**KIRKLEES METROPOLITAN COUNCIL  
INVESTMENT & REGENERATION SERVICE**

Reference No:	<b>2026/62/90450/E</b>
Site Address:	26, Foxglove Road, Birstall, Batley, WF17 9NW
Description:	Erection of two storey side extension and associated alterations
Recommending Officer:	Nicole Helliwell

## **Officer Report**

scale 1:100 date 01/2026 sheet size A2 dwg. no. 26/1283/04c

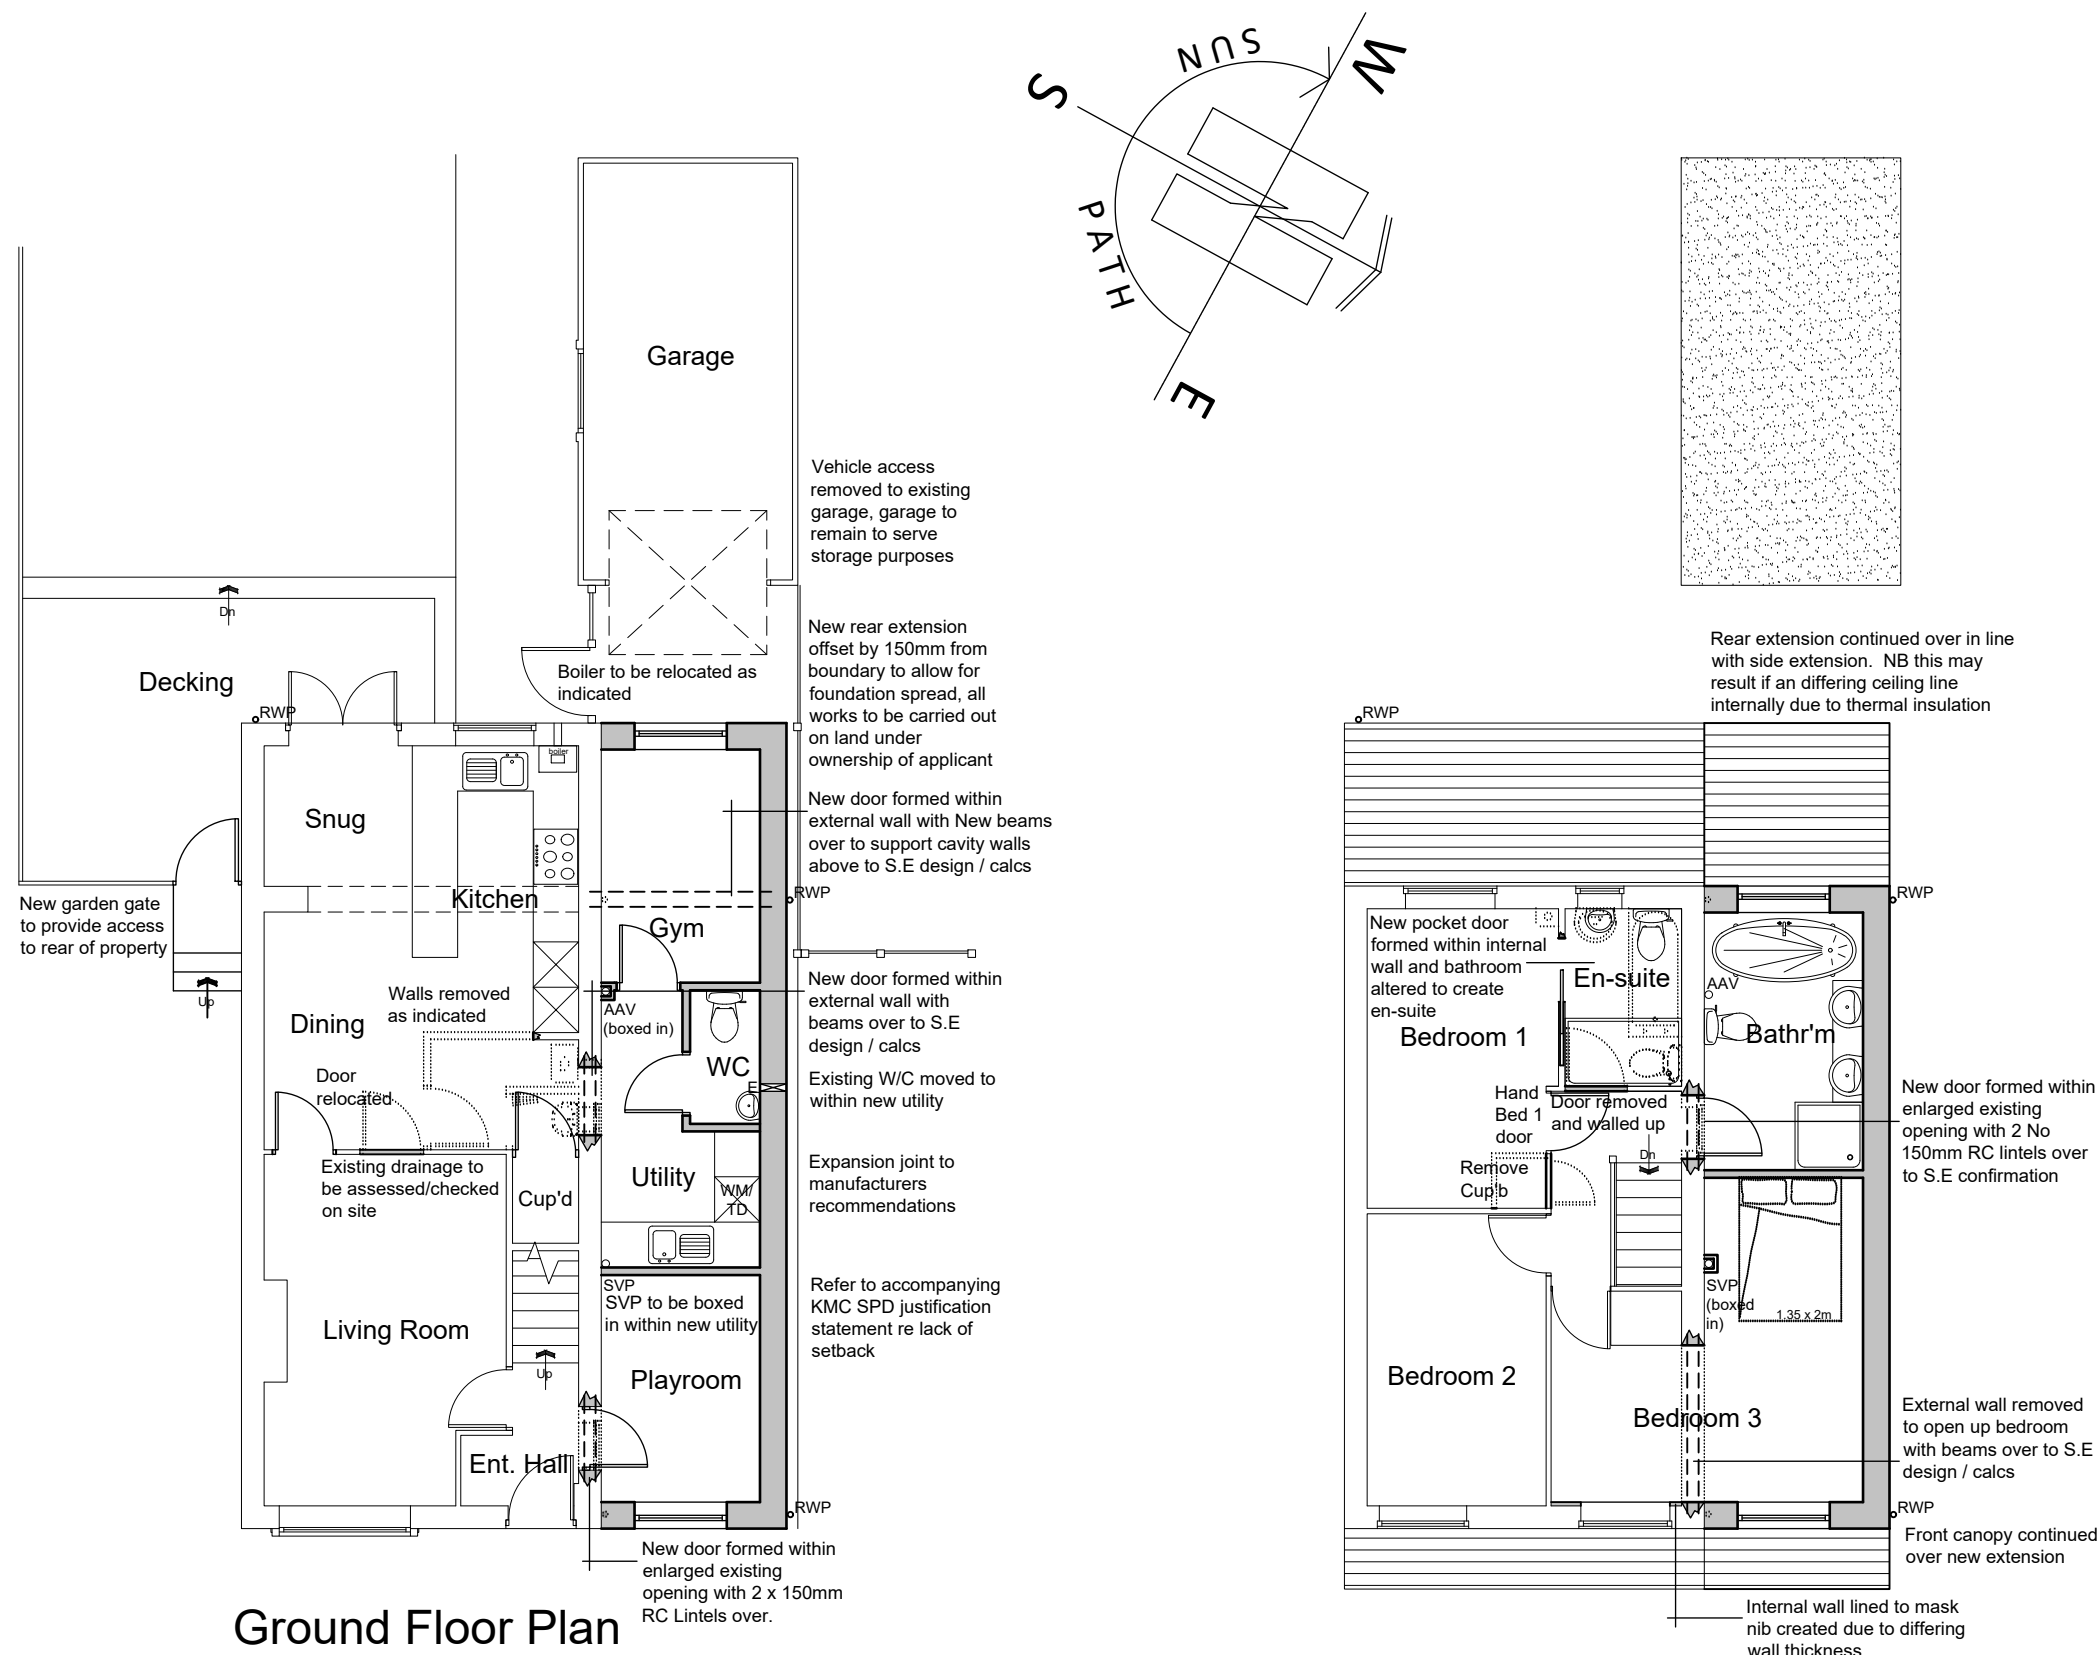
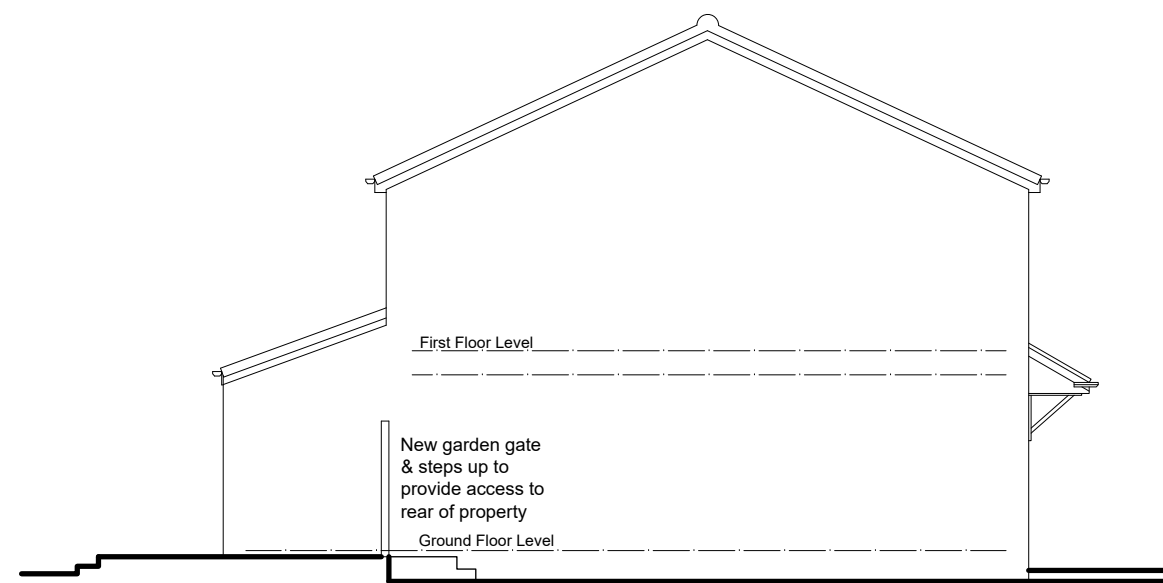
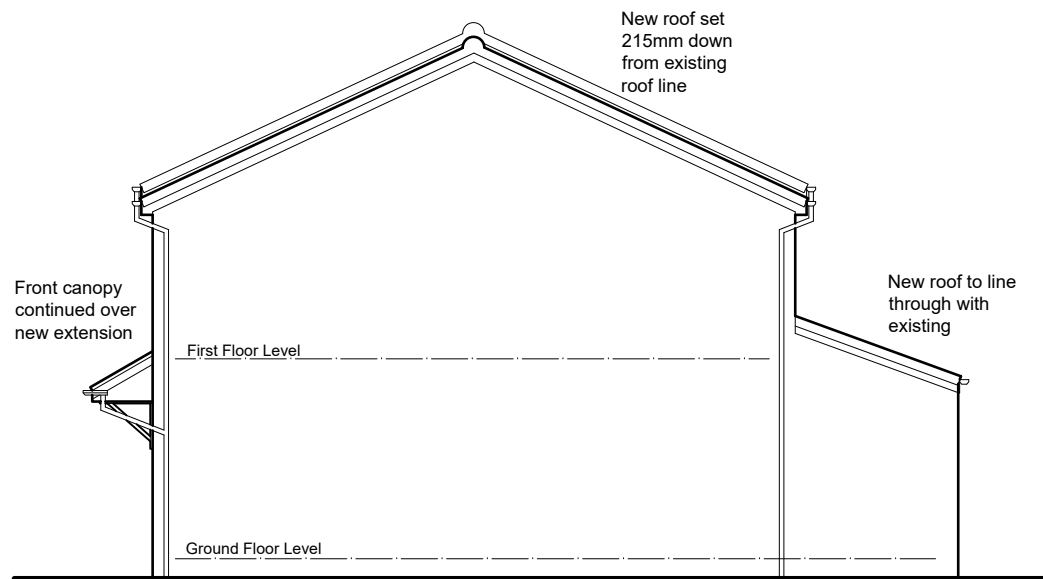
Amendments were sought during the course of the application. A request was made to lower the ridge line of the extension to enhance its subservience and lessen its visual impact. Revised drawings were received which were considered acceptable with regard to visual amenity.
